Further to submission of application LU/305/19/RES I have viewed the documentation and plans submitted and have made my **recommendation in two parts as follows:**

APPLICATION NO: LU/305/19/RES

Site Address: Parcel A2/B6 Hampton Park Toddington Lane Littlehampton BN17
7PL

Description of Works: Application for Reserved Matters following outline permission
LU/47/11 for 46 dwellings - This application may affect the setting of
a Listed Building - This is a resubmission of LU/379/18/RES

A088461 LA300-303[L].dwg

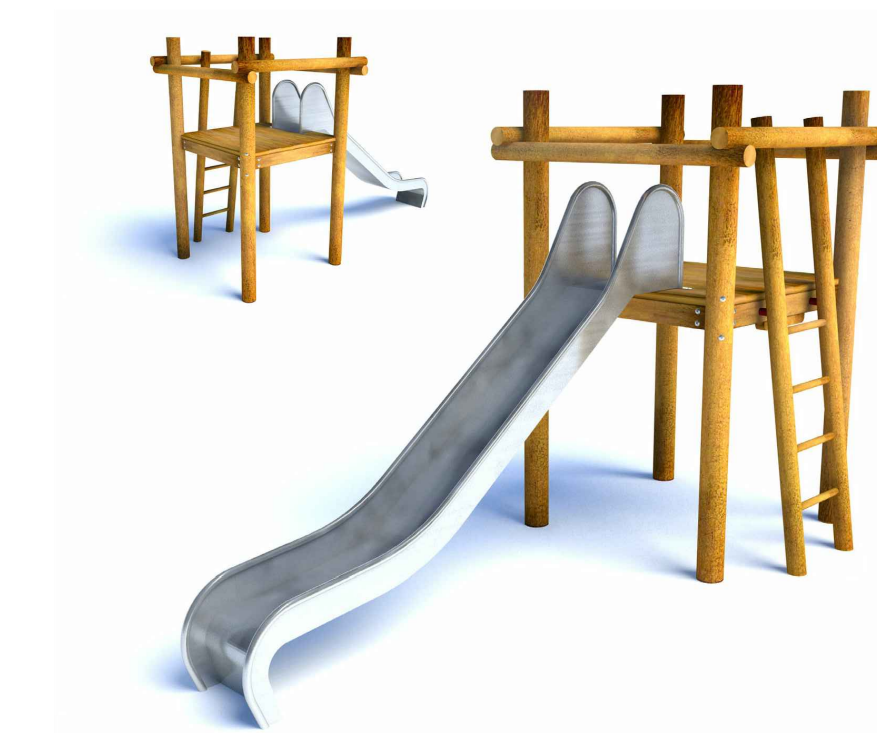
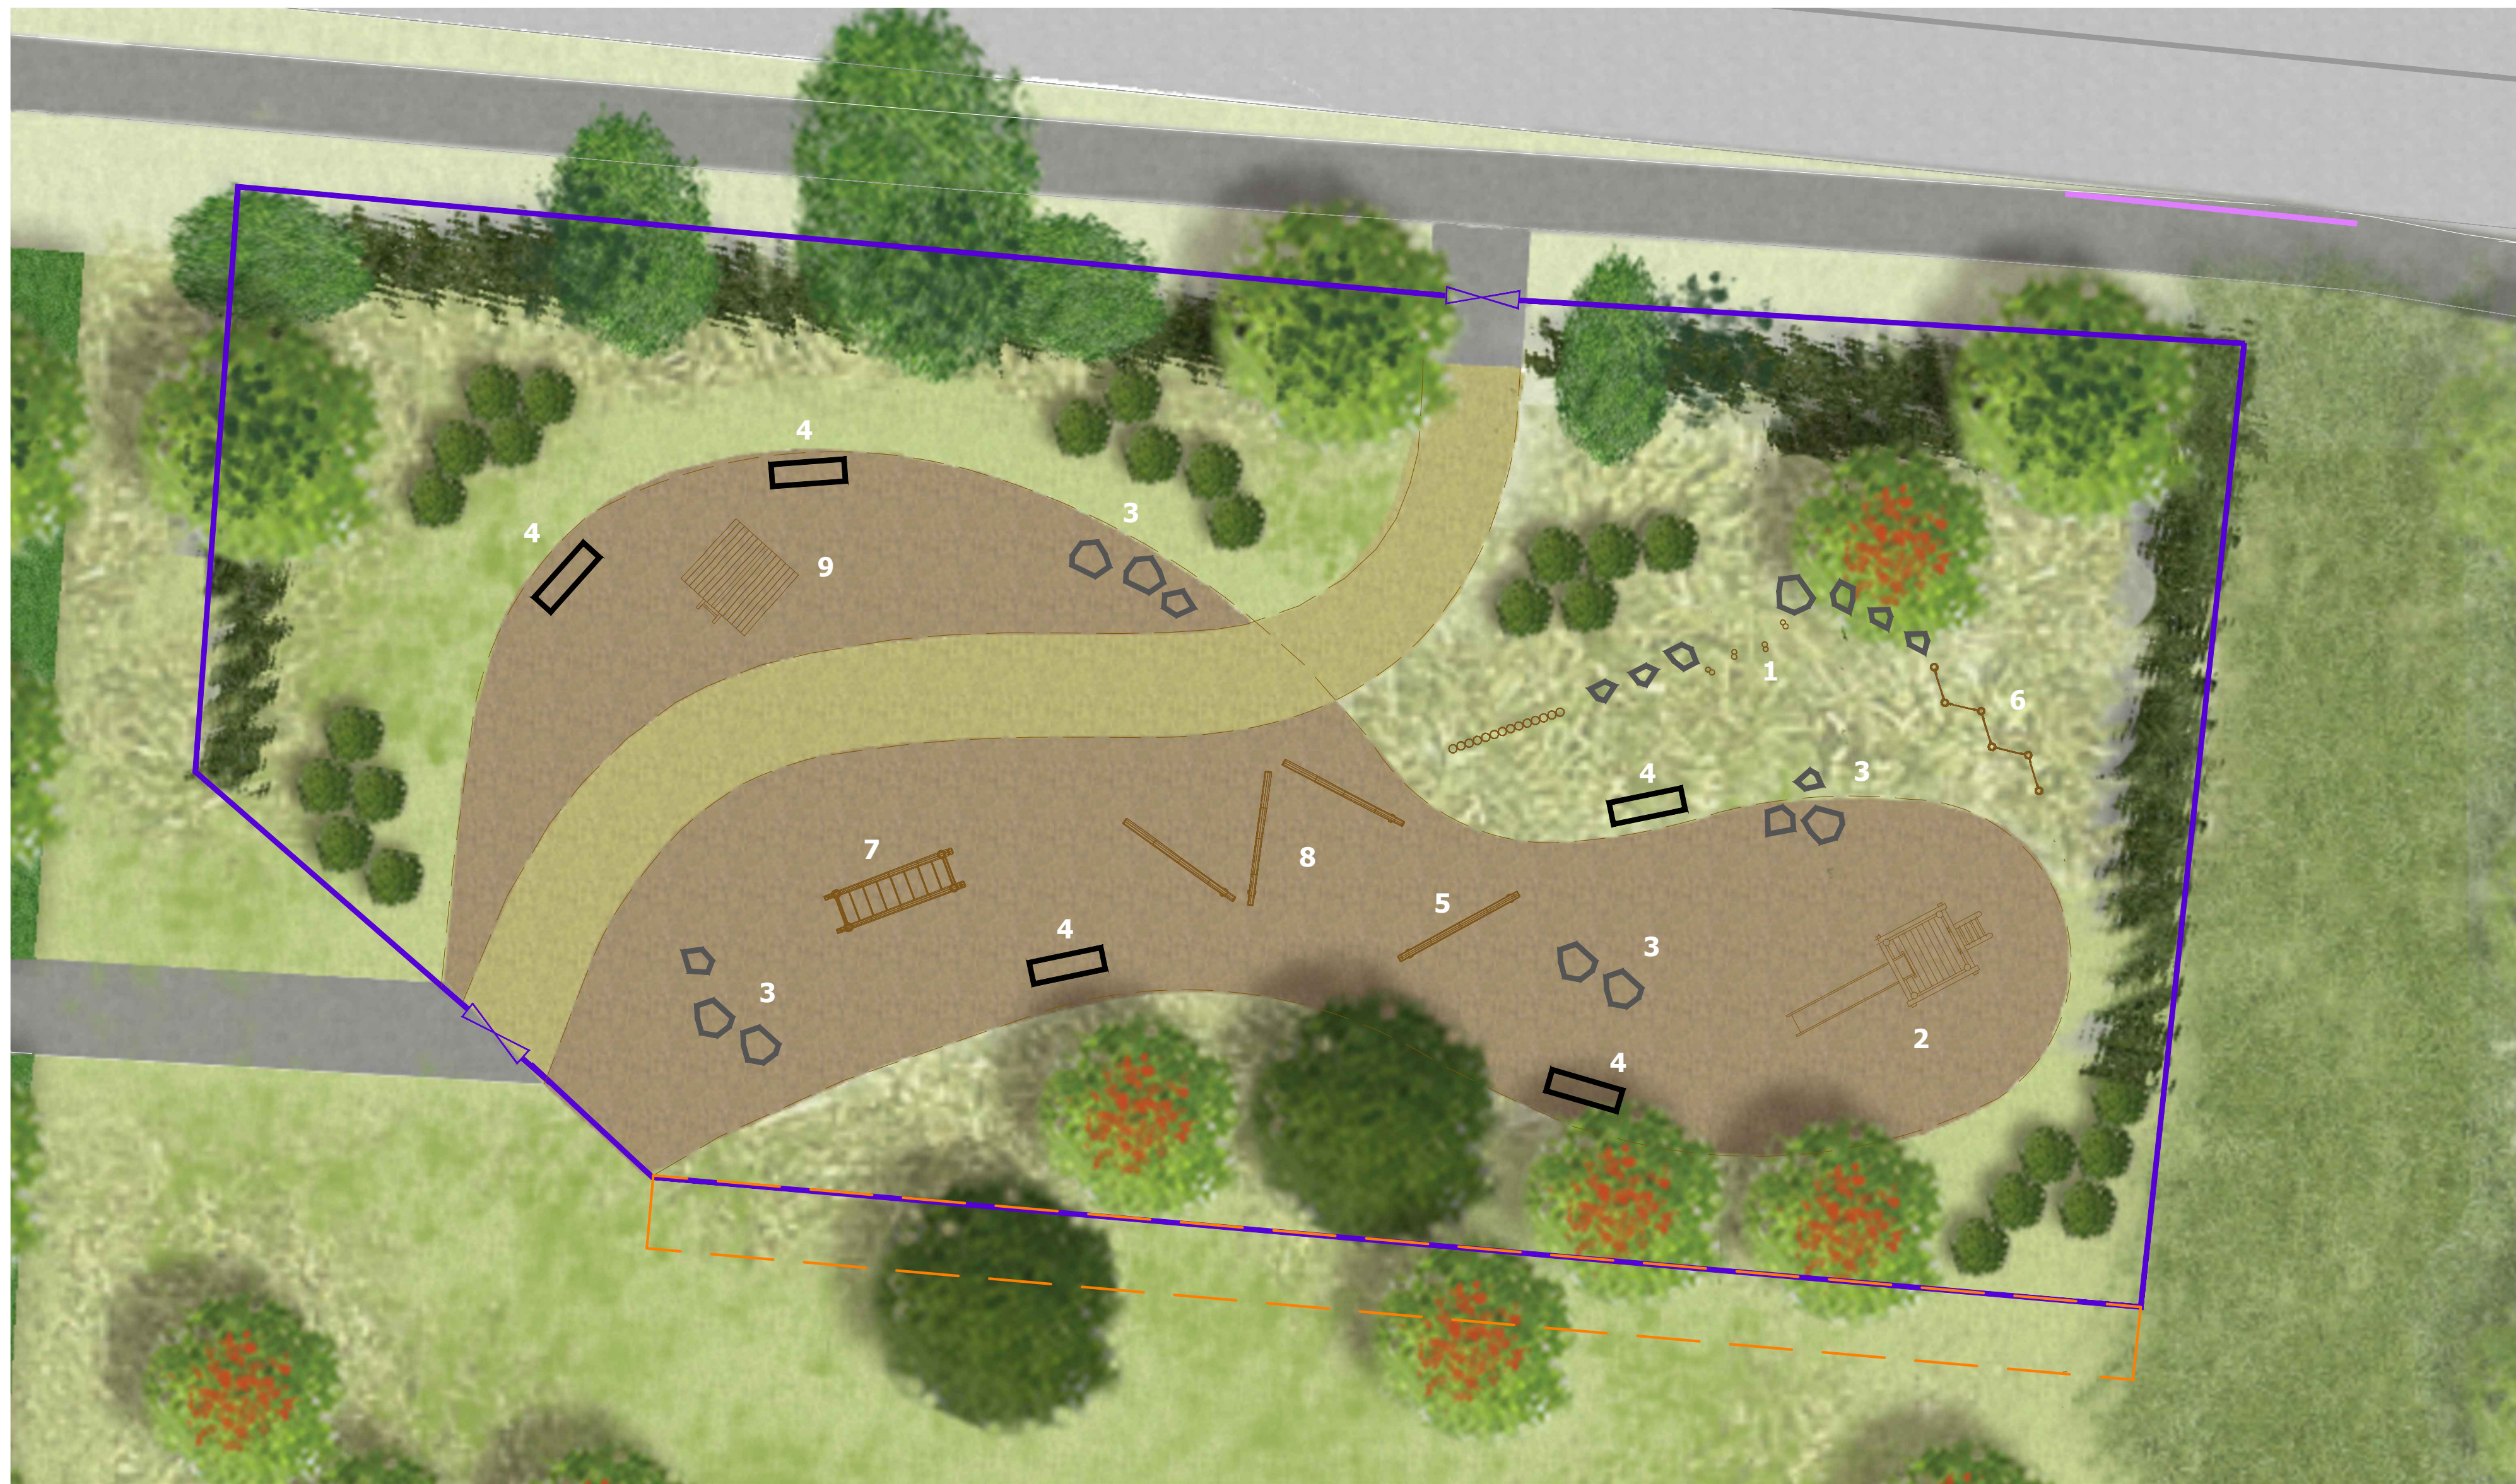
LEAP design Dwg LA 303 REV L LA 300-303 (L) has proposed a spacious and well located play area, however the play offer contained would appear to be too limited in play experiences proposed. The play has focused largely on climb and balance and whilst the choice of material – wooden is good and the items themselves ok, due to the limited experience being offered I would recommend that swing, spin, twist possibly rock are incorporated into this LEAP design. My understanding is, that as this was to be a double LEAP- due to under provision on another phase then the incorporation/substitution of further play experience here is imperative. I would like to see this additional play in the same material palate which is good and suitable for location. I would add a note of caution re the safety surfacing being bark mulch as this has the tendency to provide maintenance issues going forward, but defer to your play advisors for consideration. Pathway, gates and seat, good to see incorporated, the addition of a litter bin would also be useful to see. One of the access gates would need to be accessible for maintenance operations.

We would have to advise that I would **NOT recommend the approval** of reserved matters on this application LU/305/19/RES **relating to LEAP** until the points I have raised above have been considered and addressed.
